UNSW Health Translation Hub, Randwick Hospital Campus

Preliminary BCA and Certification Assessment

SCH - Bridge Connection - Floor Plan

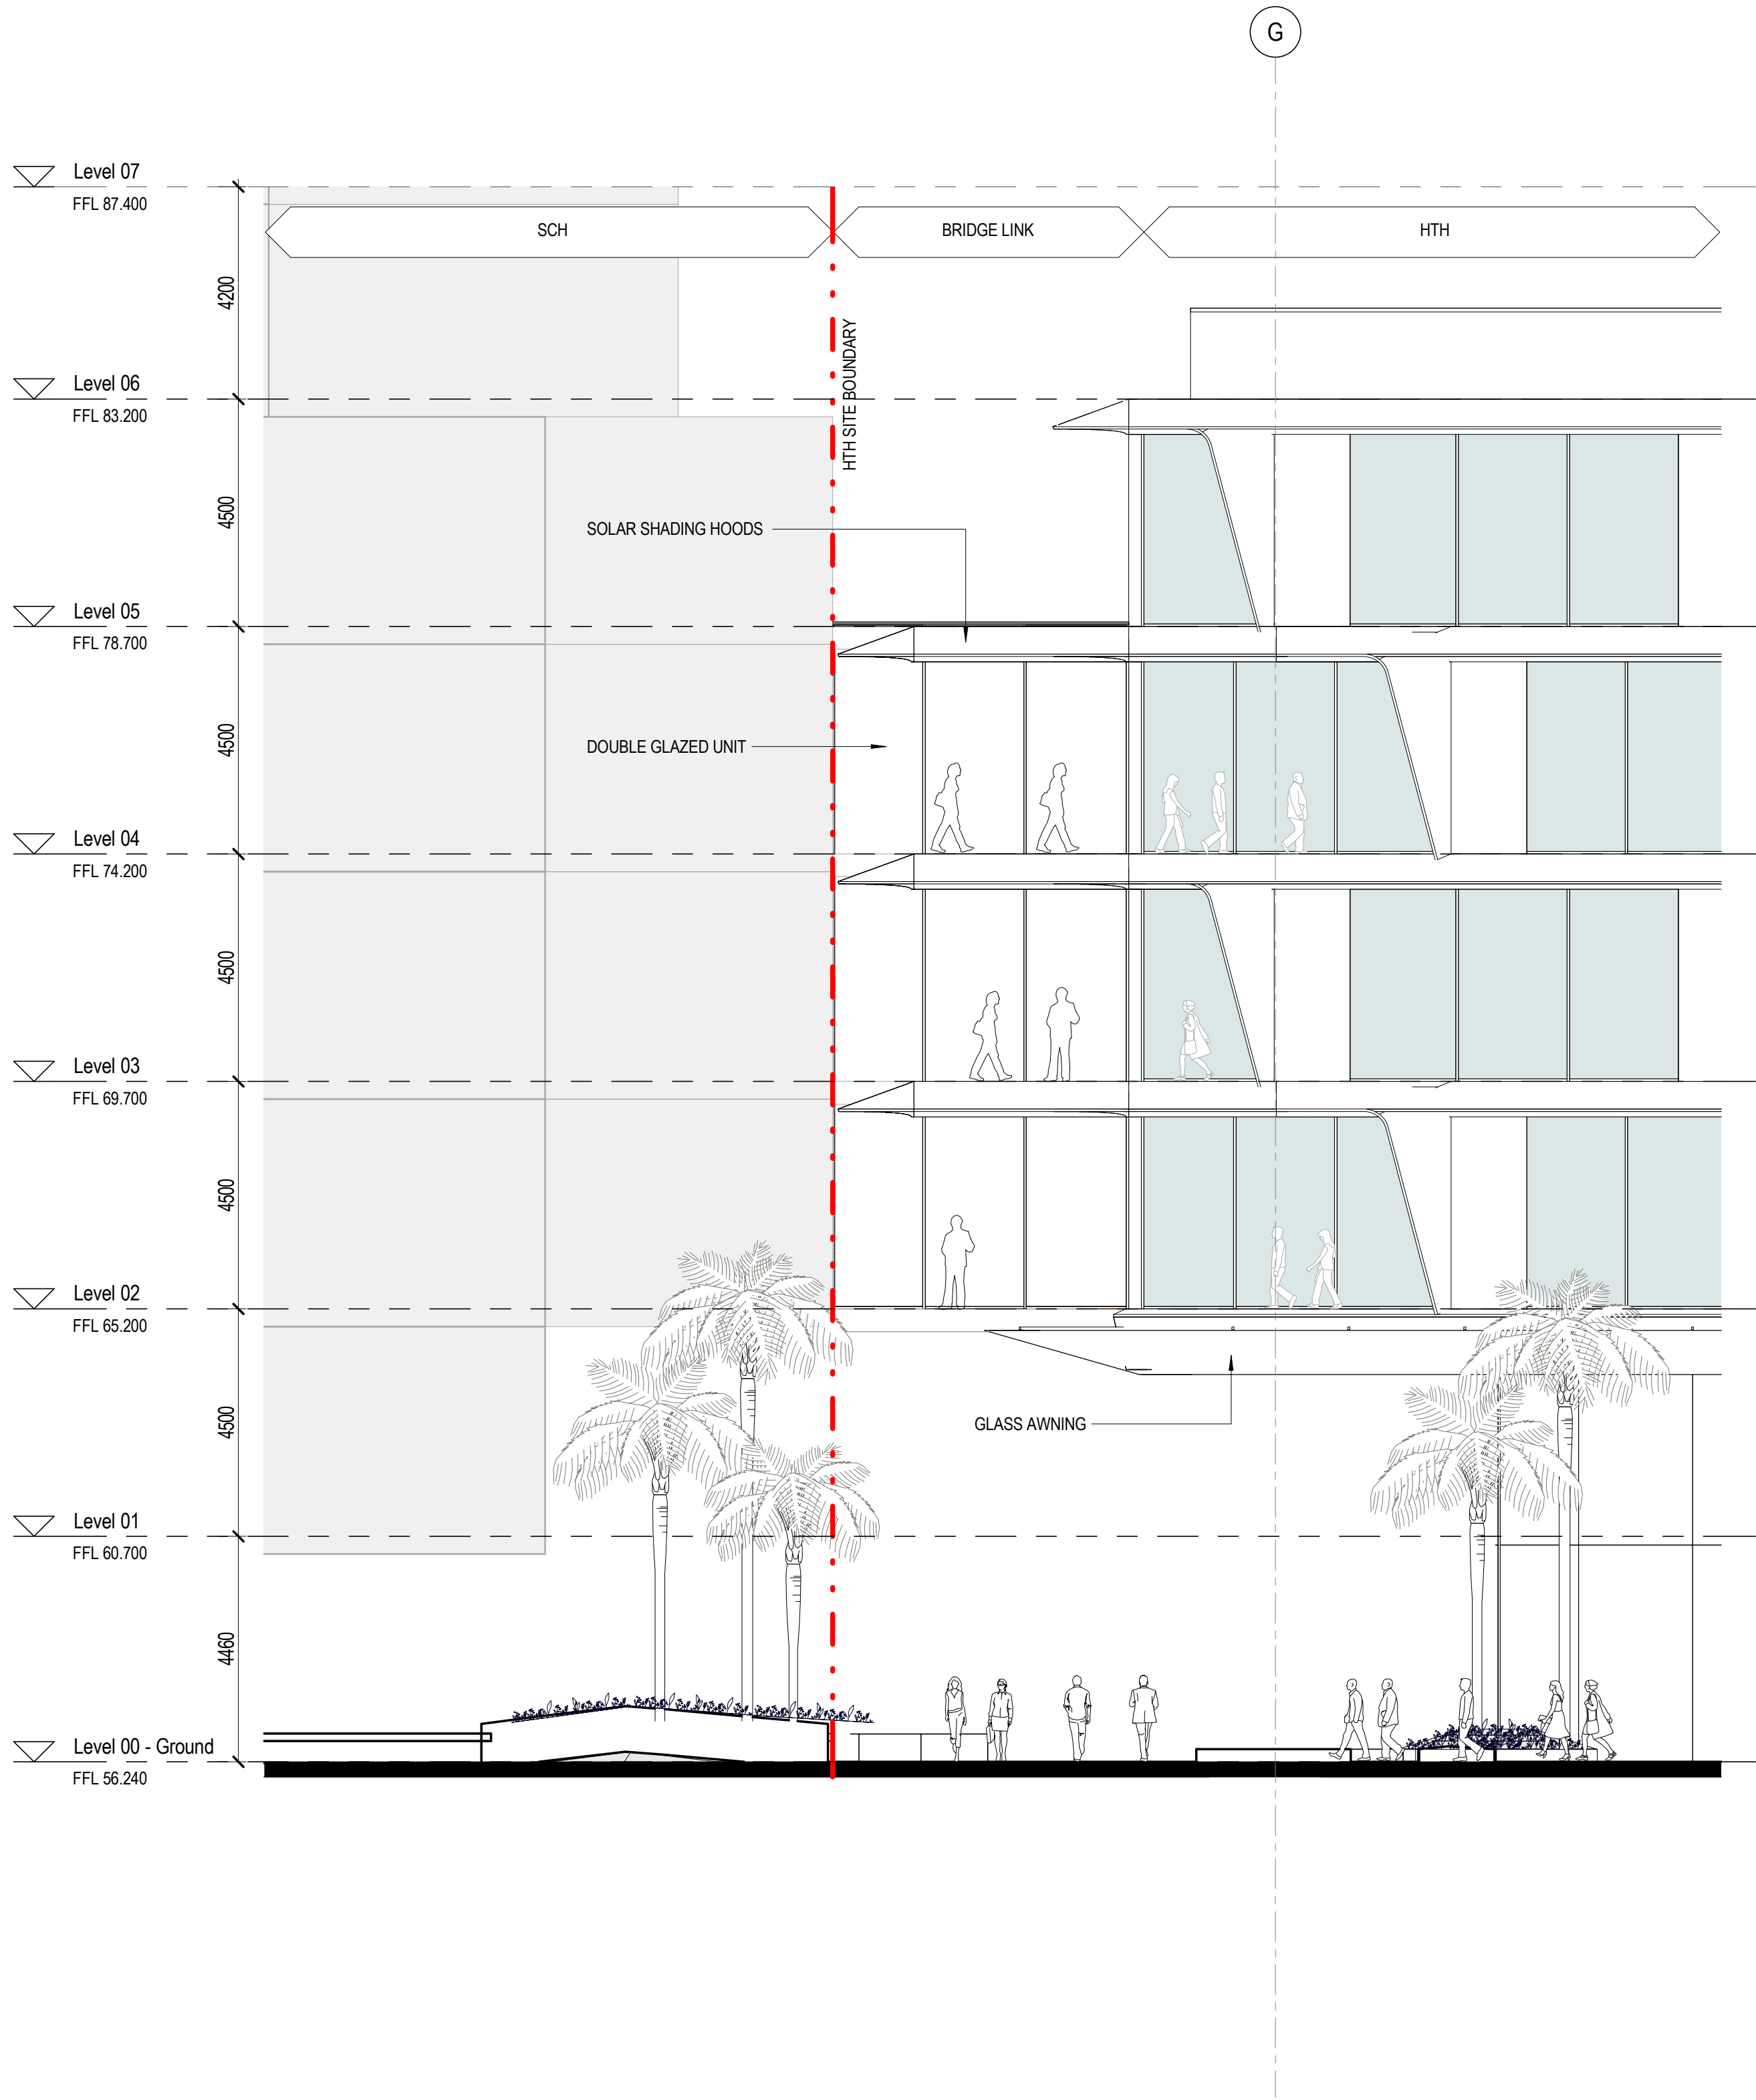
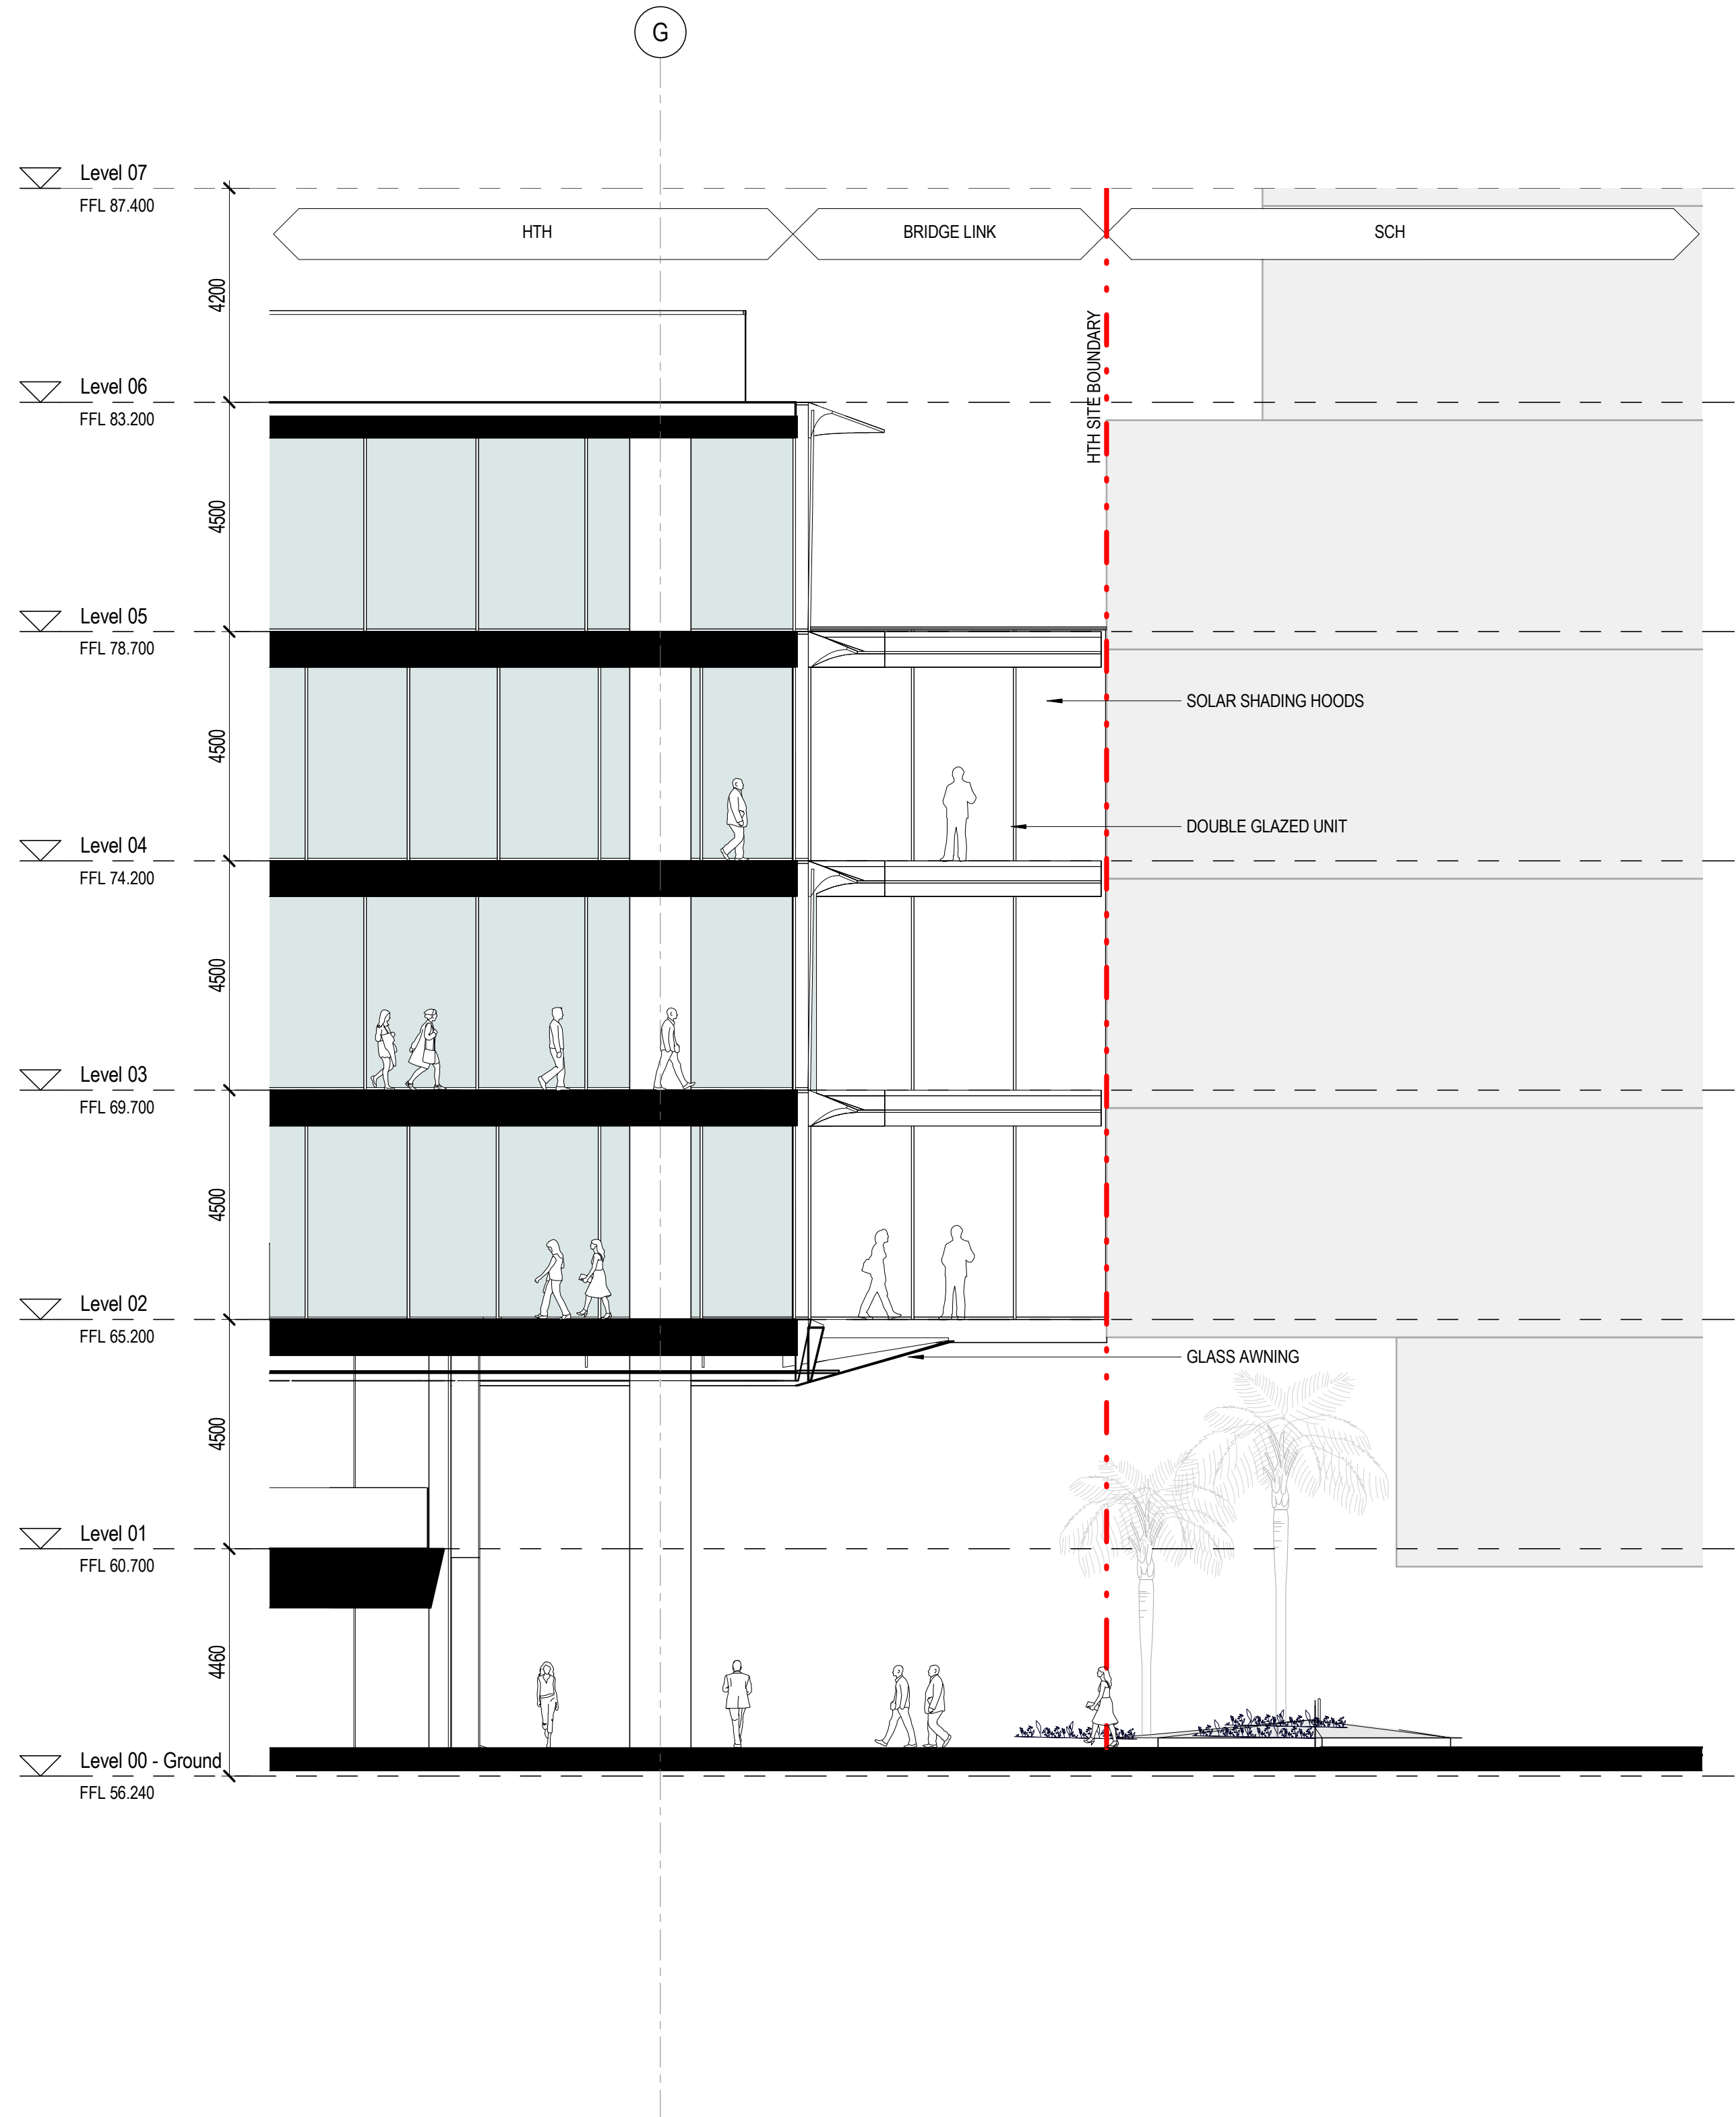
The proposed bridge links to the SCH and Wallace Wurth over Botany Rd cross over property boundaries. The external walls of the bridge link will be within 3m of the side boundary or 6m of the far boundary of the road. Separation between buildings and the protection of external walls and openings will need to be addressed.

3.	Separation by fire walls	C2.7	The proposed bridge links to the SCH Stage 1 and CCCC and Wallace Wurth over Botany Rd cross over property boundaries. The separation is proposed to be addressed under a Fire Engineered Performance Solution	CP2

4.	Protection of openings in external walls	C3.2	The proposed bridge links to the SCH Stage 1 and CCCC and Wallace Wurth over Botany Rd cross over property boundaries. The protection of openings is proposed to be addressed under a Fire Engineered Performance Solution	CP2 and CP8

5.	Doorways in fire walls	C3.5	The proposed bridge links to the SCH Stage 1 and CCCC and Wallace Wurth over Botany Rd cross over property boundaries. The doorway openings separating the buildings are proposed to be addressed under a Fire Engineered Performance Solution.	CP2 and CP8
